RE: GRADING AND DRAINAGE PLAN FOR **INTEGRATED TECHNOLOGIES**  
SUBMITTED FOR BUILDING PERMIT APPROVAL (F-17/D077)

# INTEGRATED TECHNOLOGIES CORP.

## GRADING PLAN & DRAINAGE PLAN

RE: GRADING AND DRAINAGE PLAN FOR INTEGRATED TECHNOLOGIES (F-17/D077)

INTEGRATED TECHNOLOGIES
GRADING AND DRAINAGE PLAN

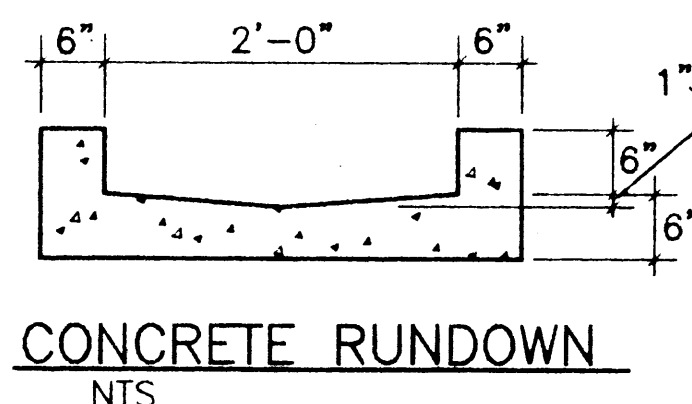
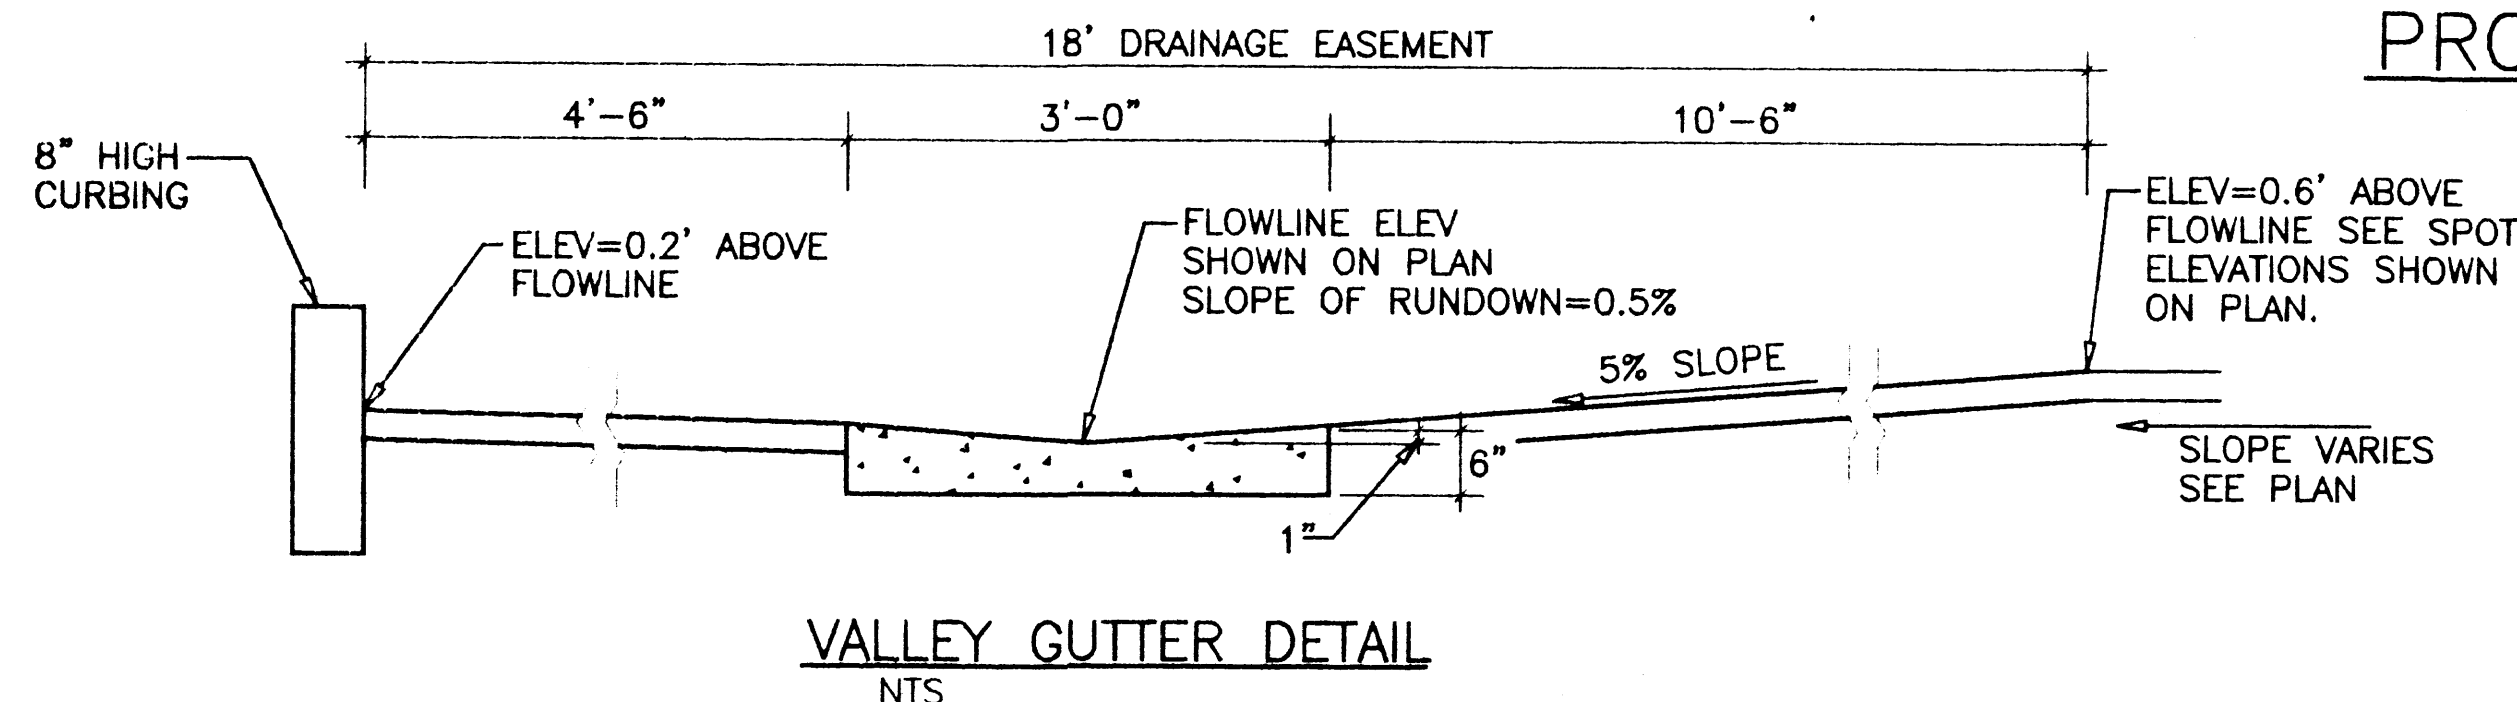
I have reviewed your submittal for the project referred to above. The only problem I find with the grading and drainage plan is the concrete rundown located on the east side of the south driveway. The design of this structure presents a hazard for pedestrian traffic. Please use the City standard sidewalk culvert instead. Installation of the standard sidewalk culvert is done under the SO 19, which will require you to submit an extra copy of the grading and drainage plan with a signature block for sign-off by Hydrology and Streets, another City standard.
